**From:** Jonathan Best <Jonathan.Best@arun.gov.uk>  
**Sent:** 11 September 2026 11:13  
**To:** Planning.Responses <Planning.Responses@arun.gov.uk>  
**Cc:** Amber Willard <Amber.Willard@arun.gov.uk>  
**Subject:** WA/85/26/DOC

Land on the West side of Yapton Lane Walberton.

I have reviewed the approval of details reserved by condition imposed under WA/2/22/OUT relating to condition 16-Biodiversity Net Gain Stage Report.

Figure 1. Redline boundary of the site and wider site boundary (blue line) (Google Satellite 2026)

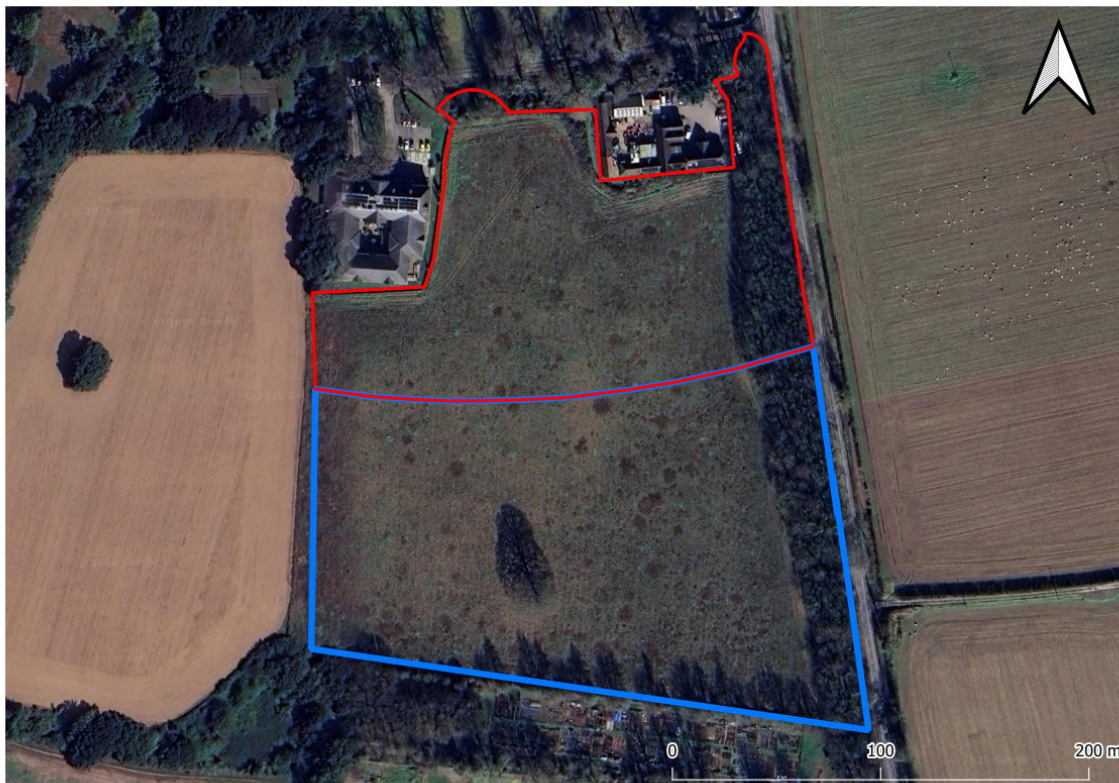
The baseline assessment of current conditions on site appears to differ from the 2022 assessment as the site shown in figure 1 does not appear to show arable habitat.

Clarification of the current baseline habitat is required.

Figure 8. Design of SUDs showing varying depths at a gently sloping level (Freshwater Habitats 2013)

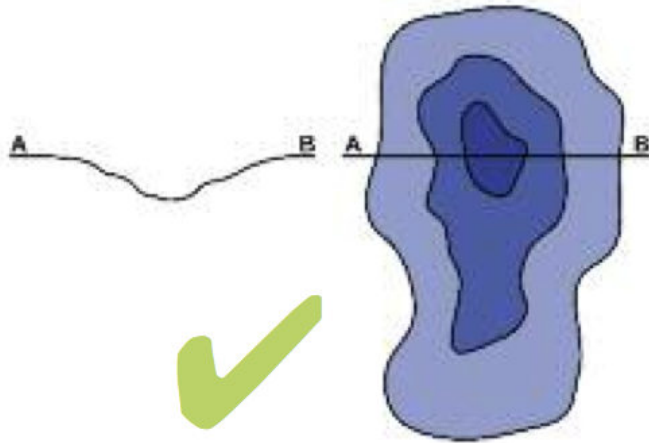
A detailed specification of the pond being created is required. The pond has a species list including Flag Iris. This plant can rapidly colonise ponds so an alternative marginal species may be better.
